Acceptance of Applications Checklist

Cory Decarbonisation Project Section 55 Acceptance of Applications Checklist

Drawing file: EN010128 / EN010128-000127-2.9 - Extended Crossness Local Nature Reserve Plan.pdf

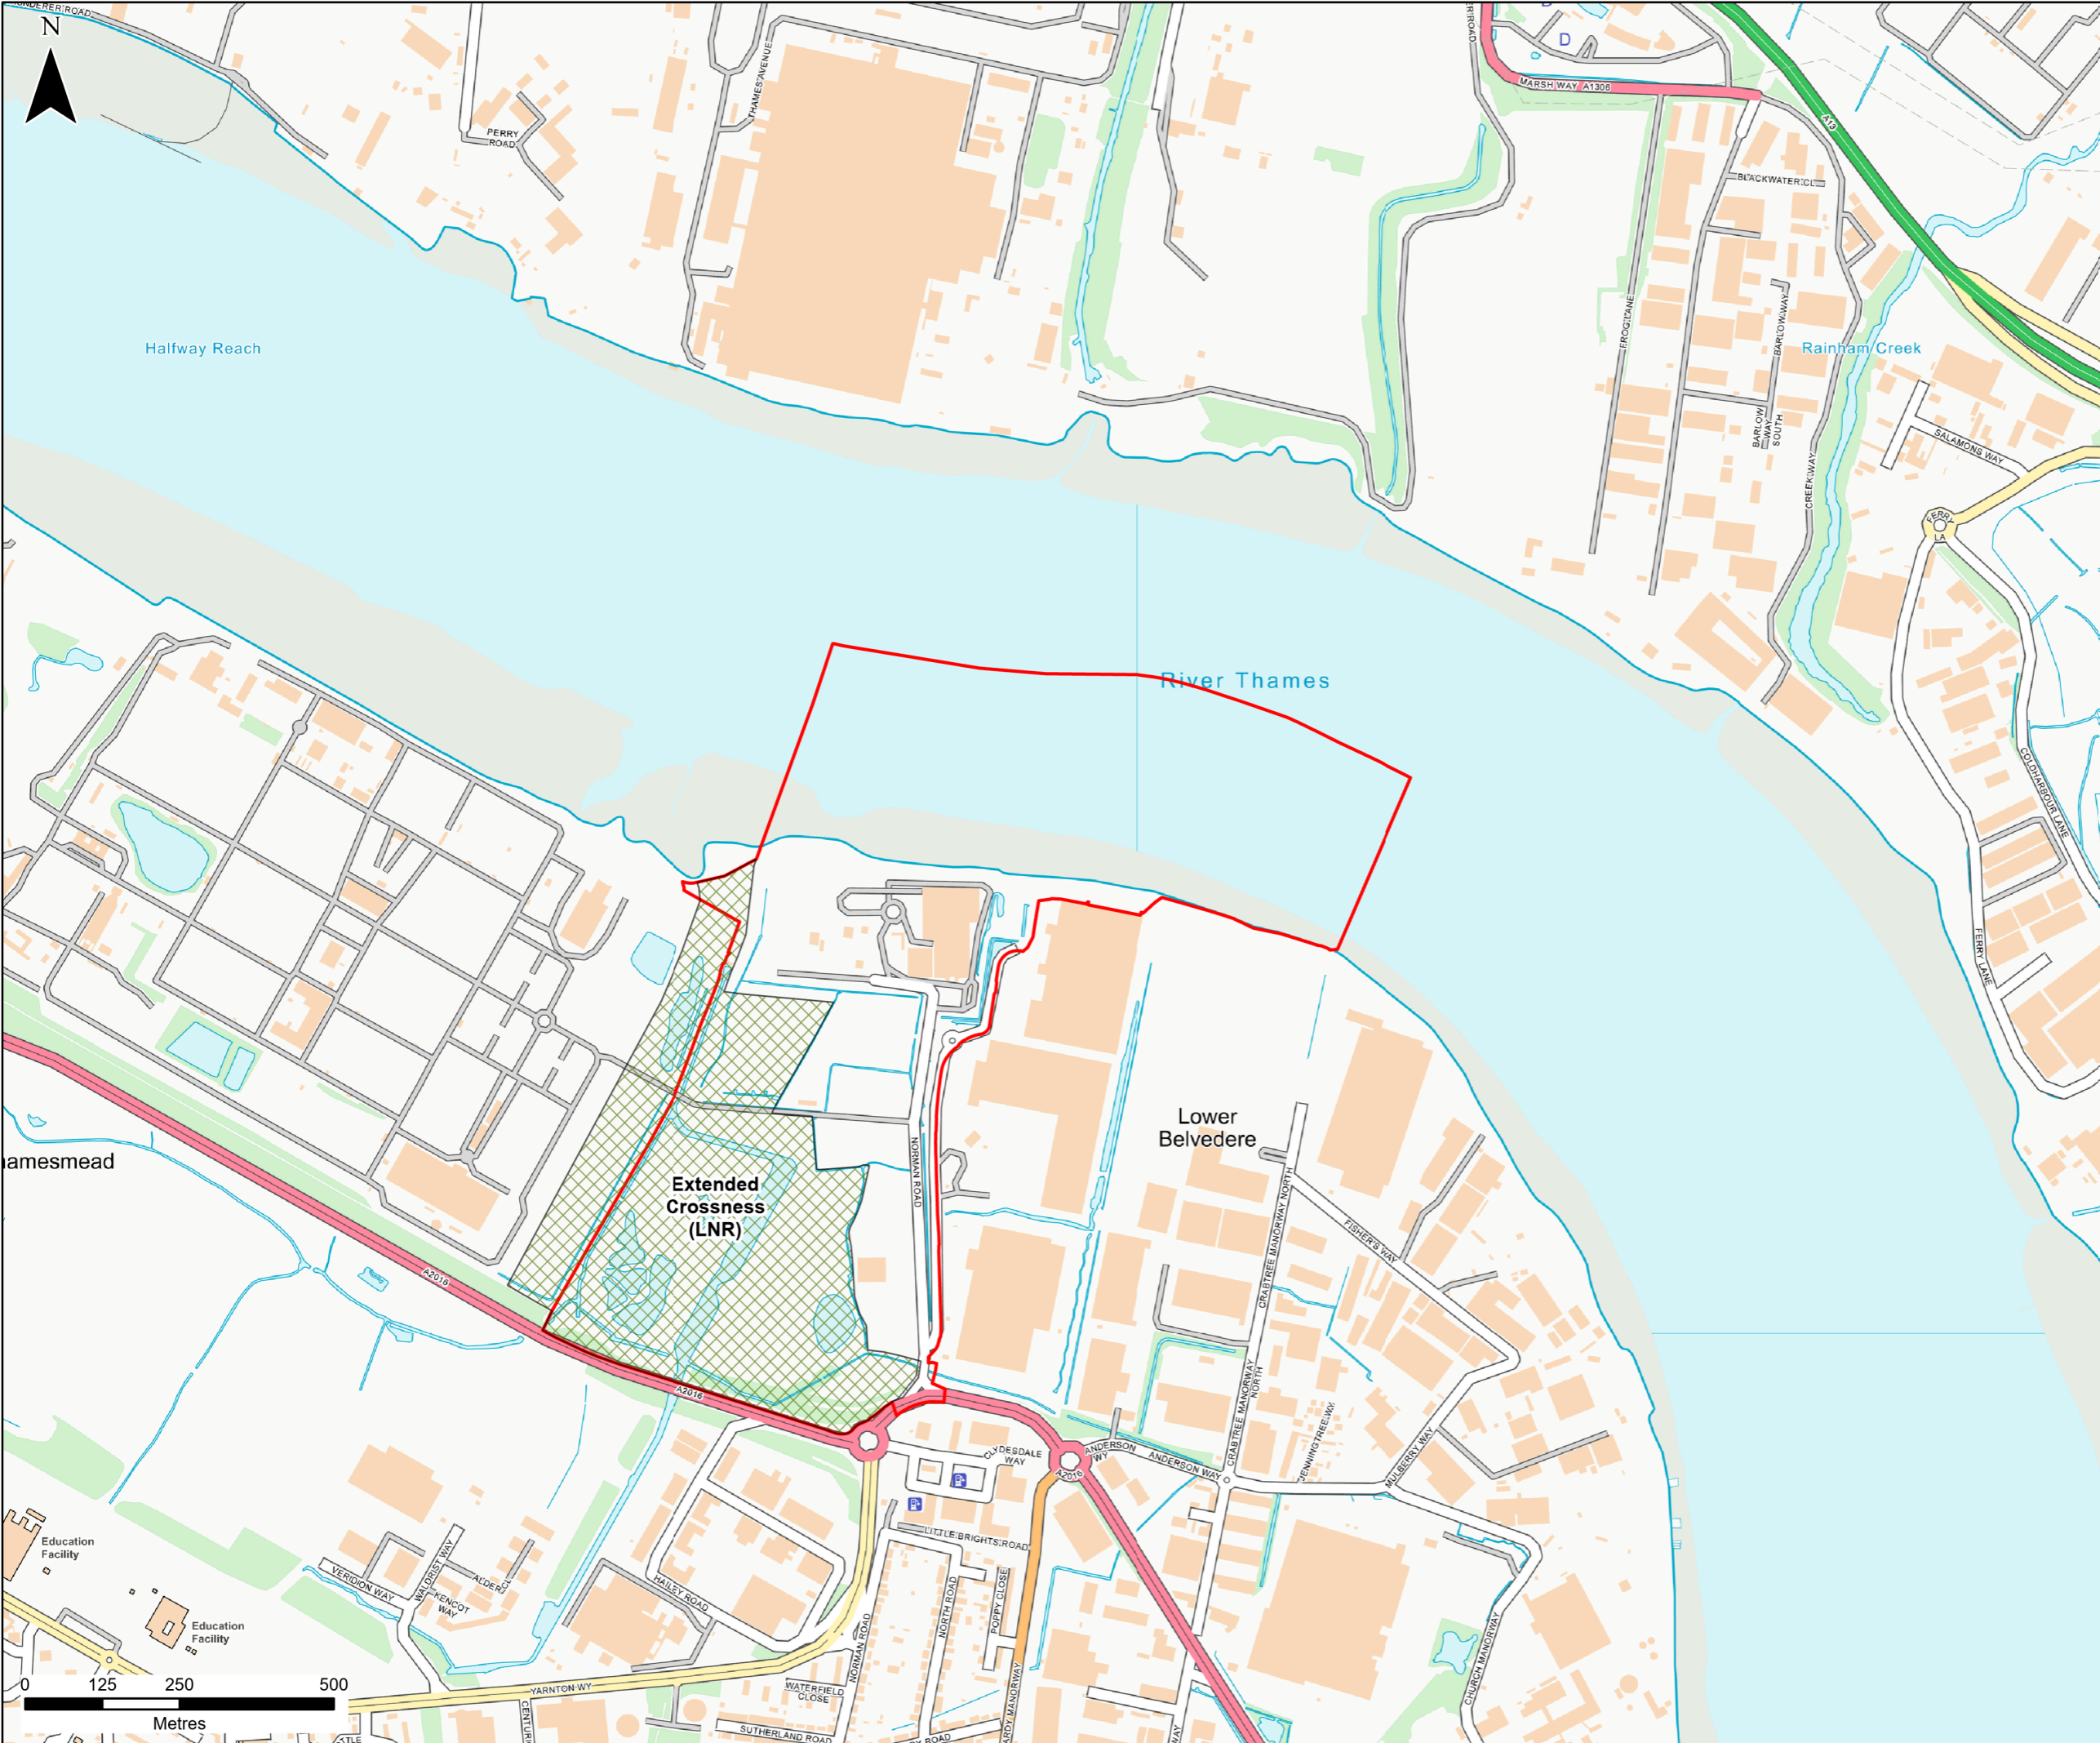
There appears to be a variety of map bases: the local nature reserve plan has adequate labelling but on most of the other plans the mapping is very faint and background detail eg street names and locations are missing, which makes it difficult for the reader to identify what is where: a common map base for all plans which is clear, legible and well labelled should be considered.
